**CITY OF ALBUQUERQUE  
PLANNING DEPARTMENT  
December 31, 2013  
DRB Comments**

**PROJECT # 1002981**

**APPLICATION # 13-70793/ 70794**

**RE: Lot B-1-A-3-A, Duke City Lumber Addition**

PROJECT NUMBER: 1002981
 Application Number: 13 DRB-70795
13 DRB-70294

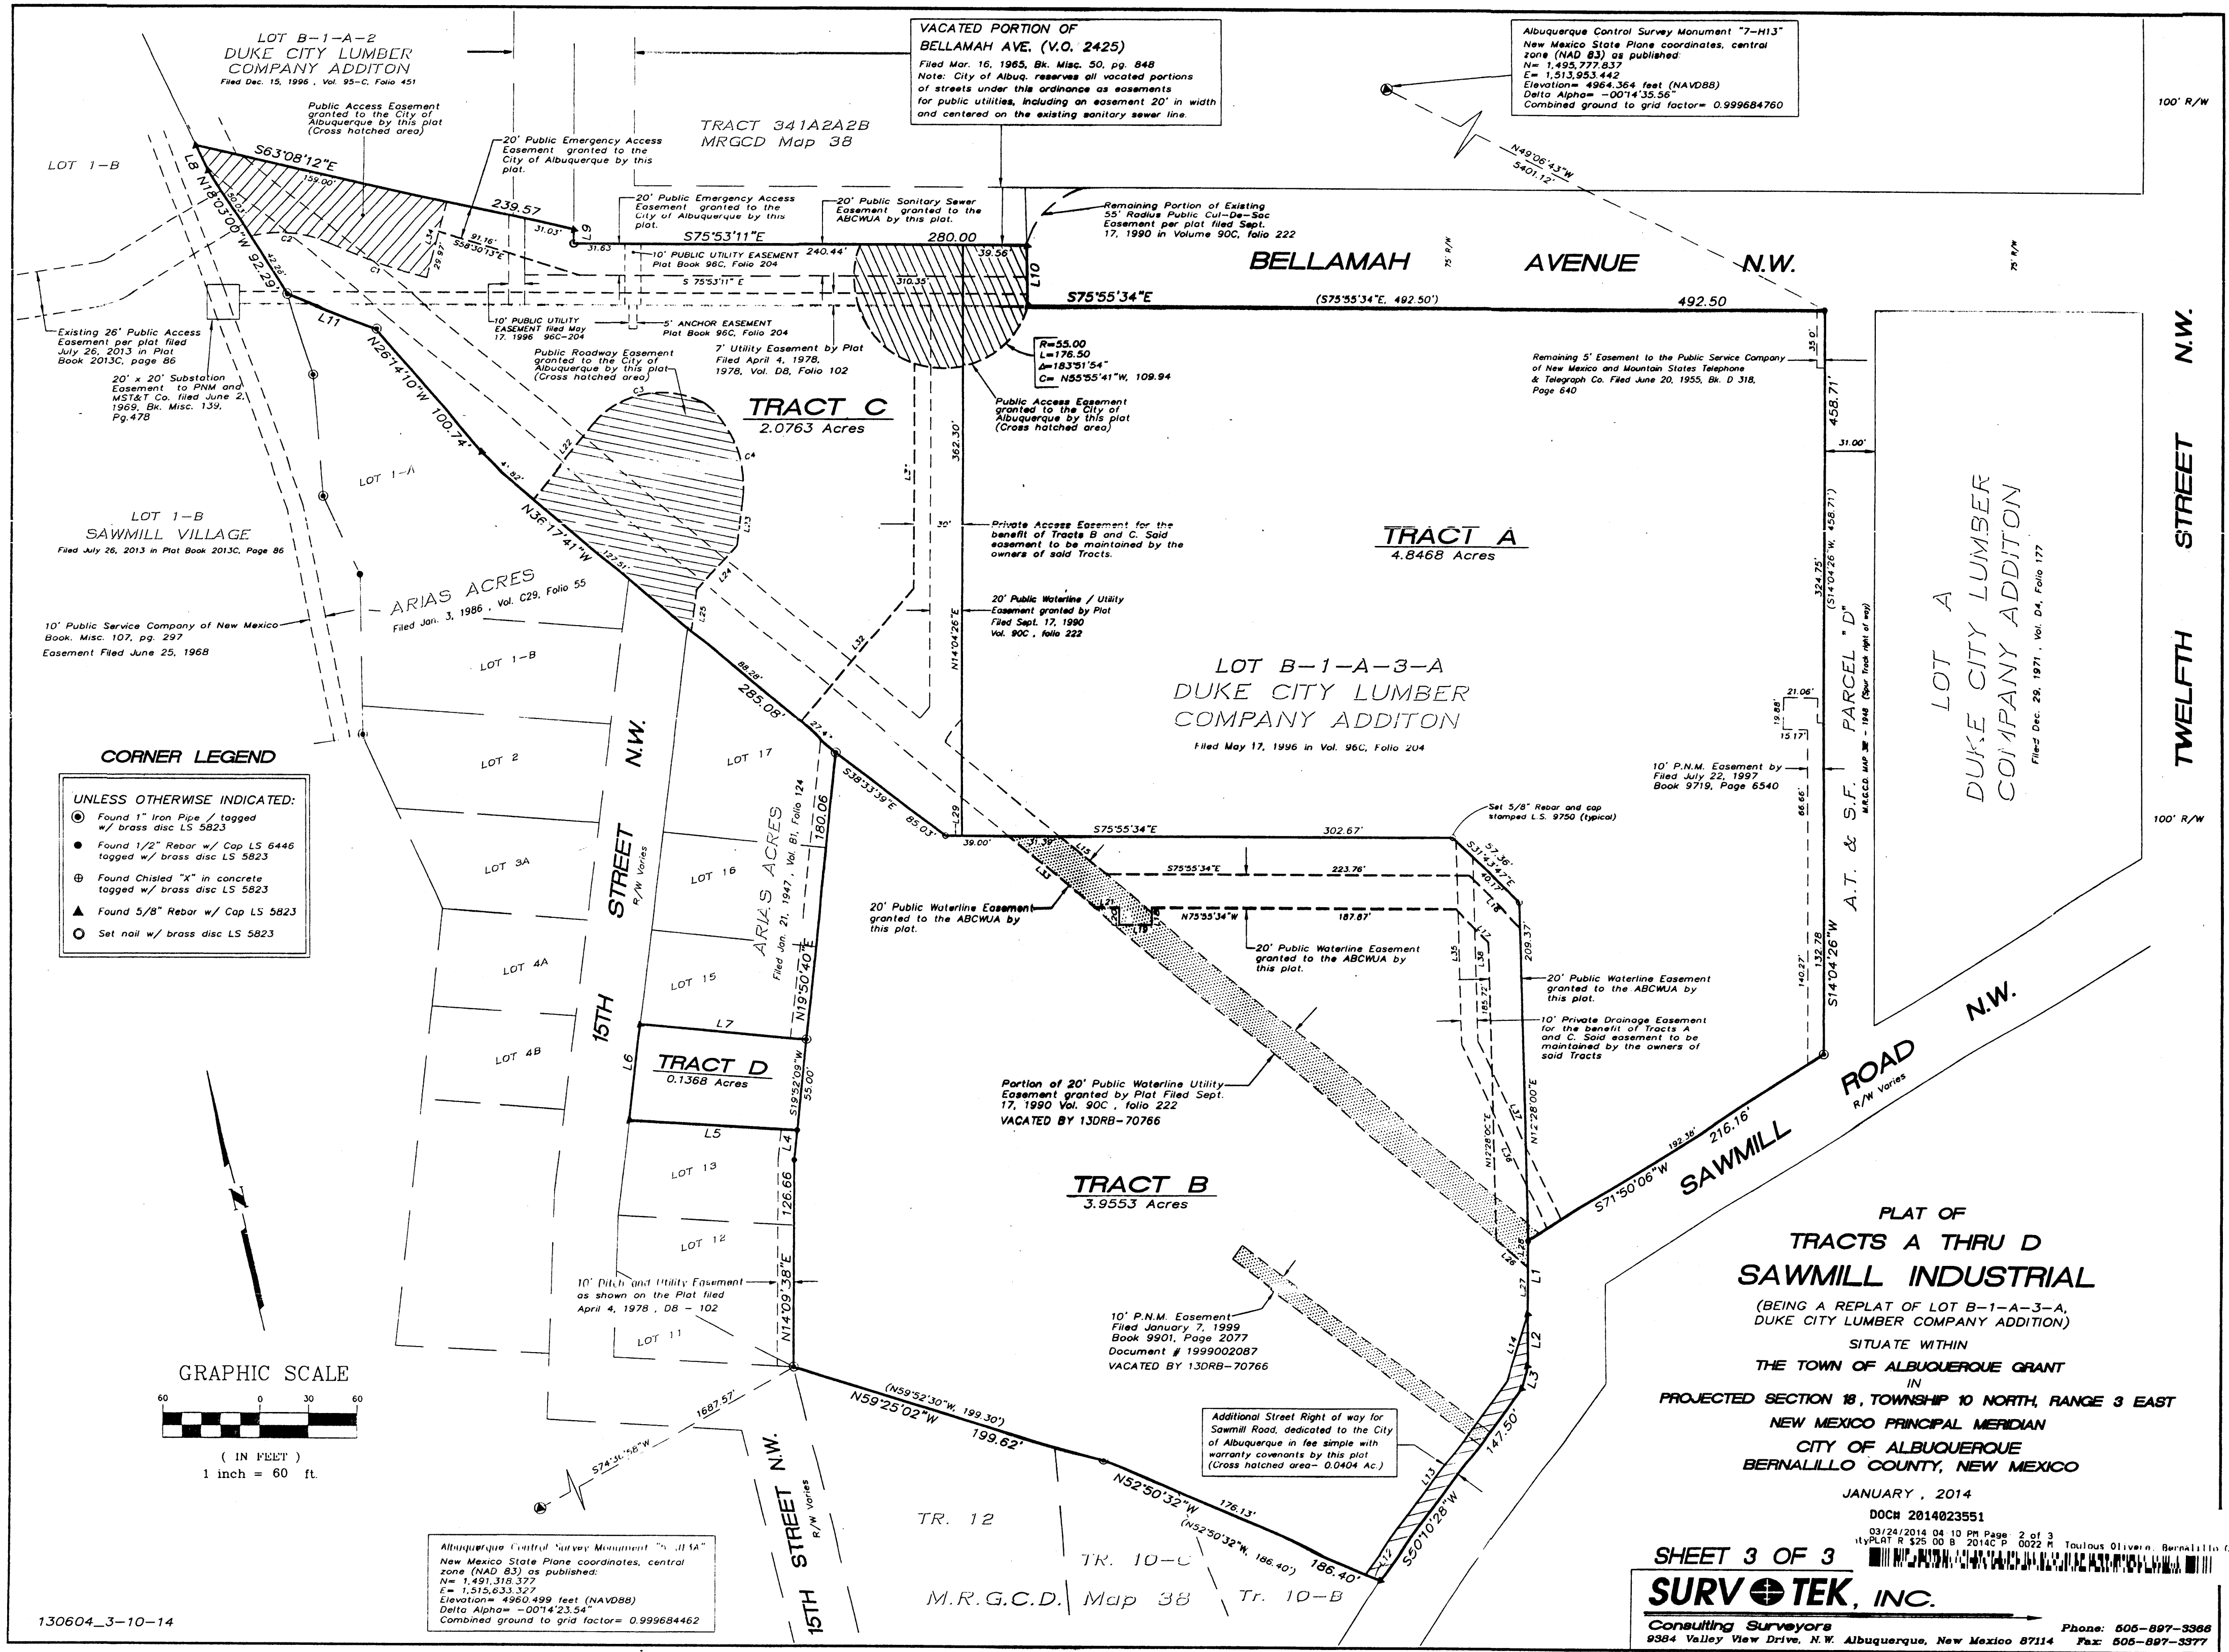
Regarding the Subdivision Design Variance for Sawmill Road, additional right of way needs to be provided at this time, with possible taper of street improvements to match existing to the south; refer to comments from Transportation Development. The Planning Department needs to record this plat to complete the vacation action.

PROJECT #: 1002981  
 DATE: 12-4-13  
 APP#: 13DBB-70769  
 -SK-

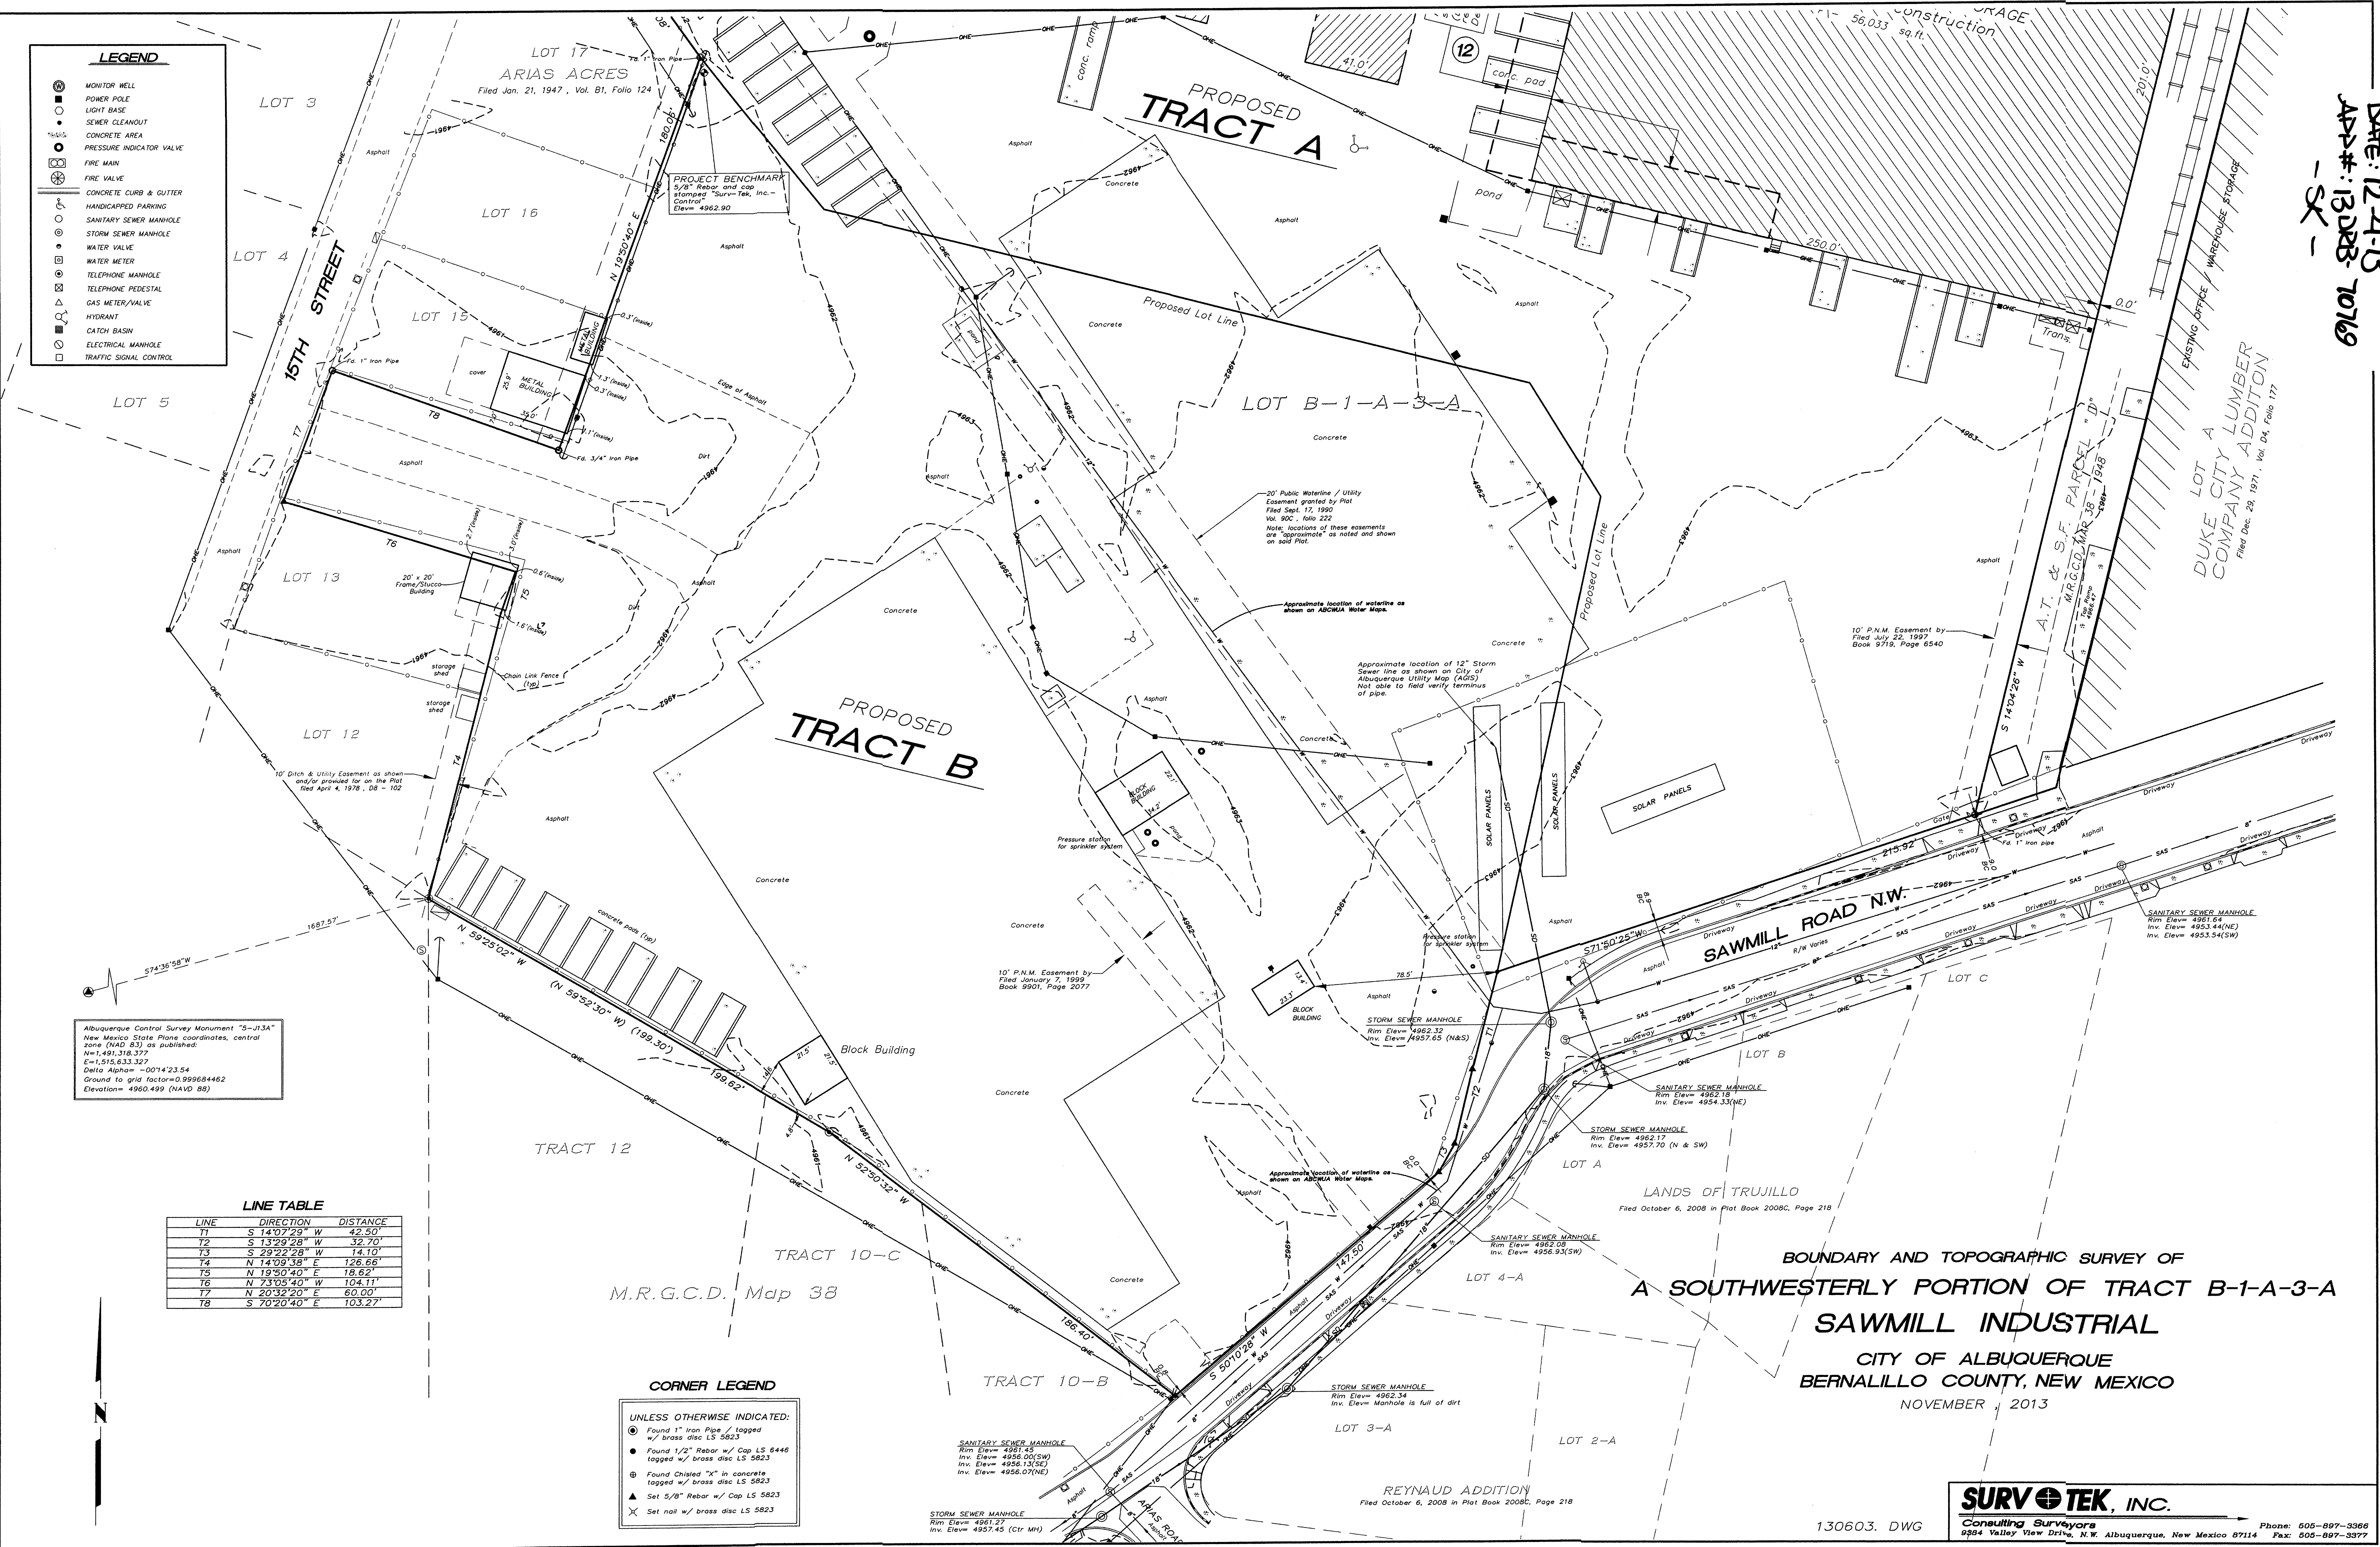
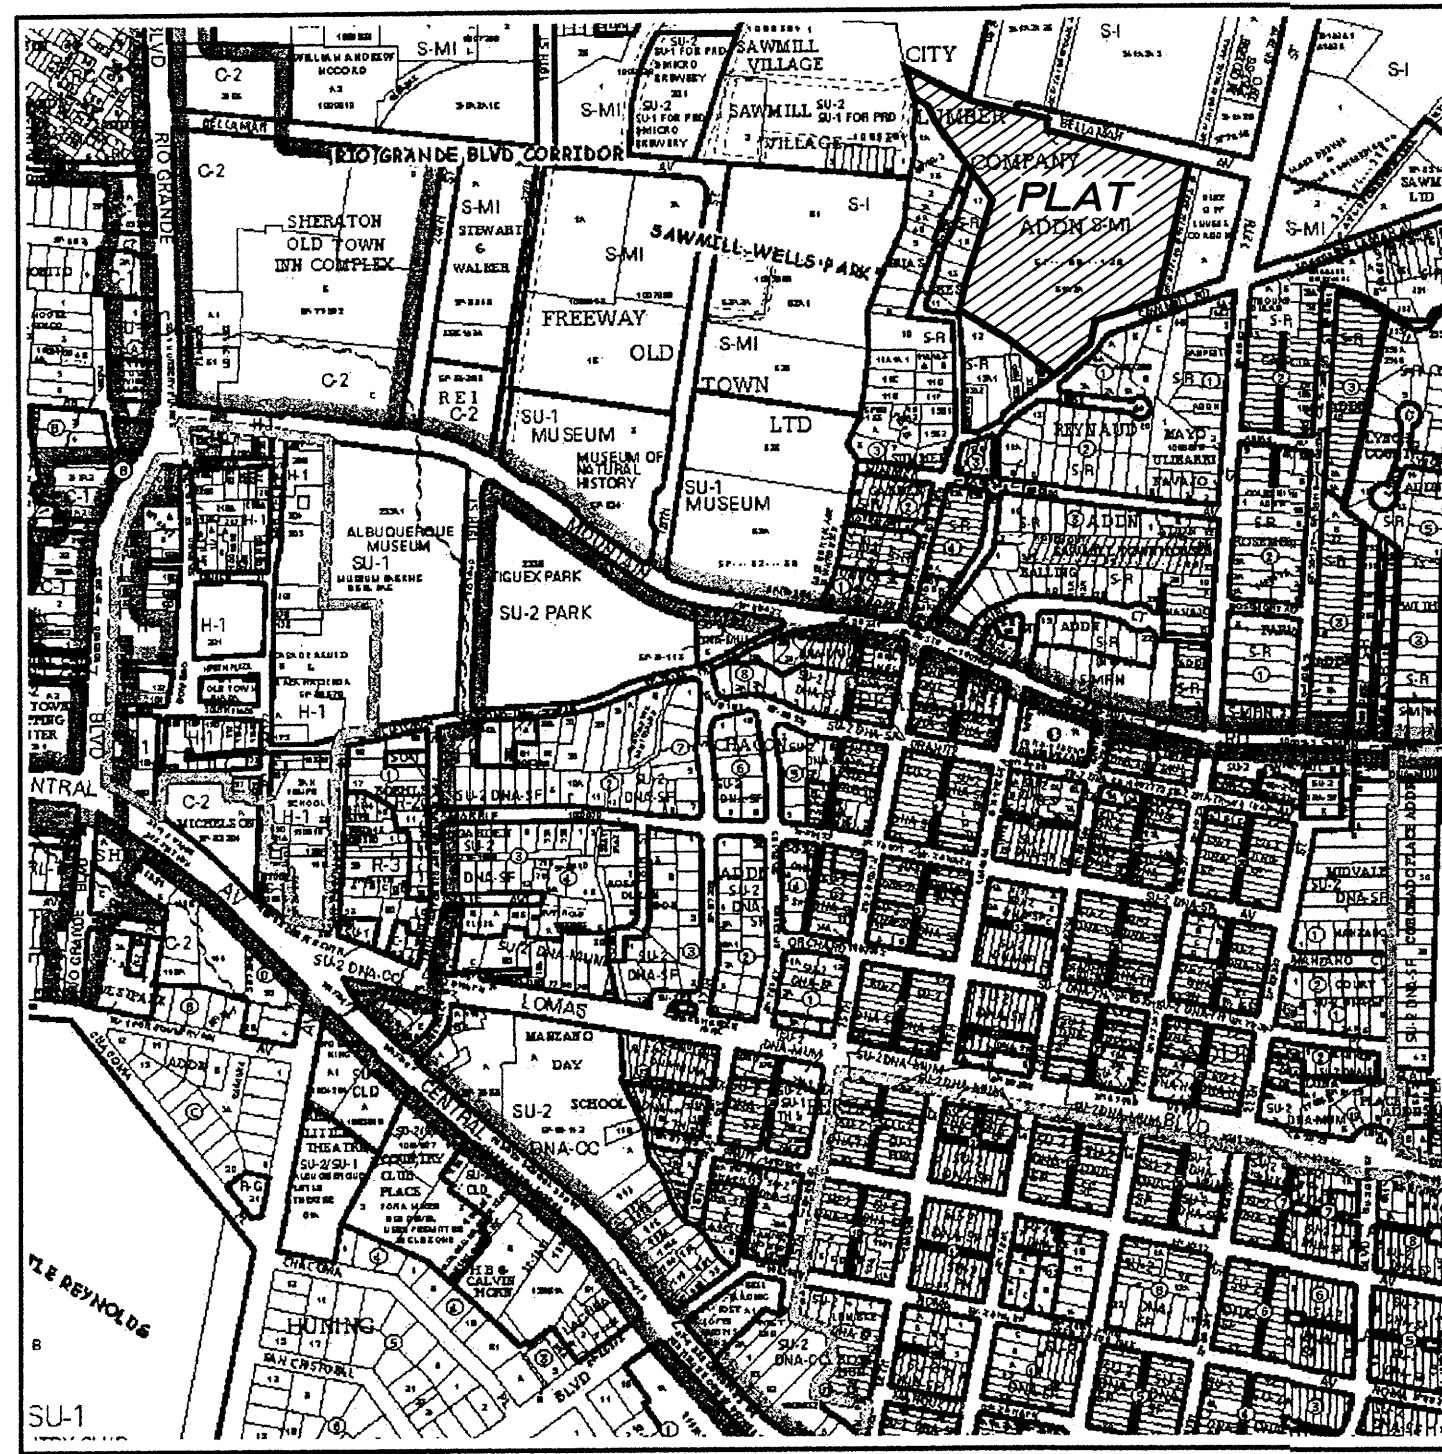
The site is zoned S-M1 within the Sawmill-Wells Park Sector Development Plan. It appears a public vehicular turnaround easement is needed for the termini of 15<sup>th</sup> St and Bellamah Ave; additionally, a roadway connection is needed to align with the Public access easement to the west on Lot 1 of Sawmill Village and proposed right of way to the north of Sawmill Crossing PRD – refer to comments from Transportation Development.
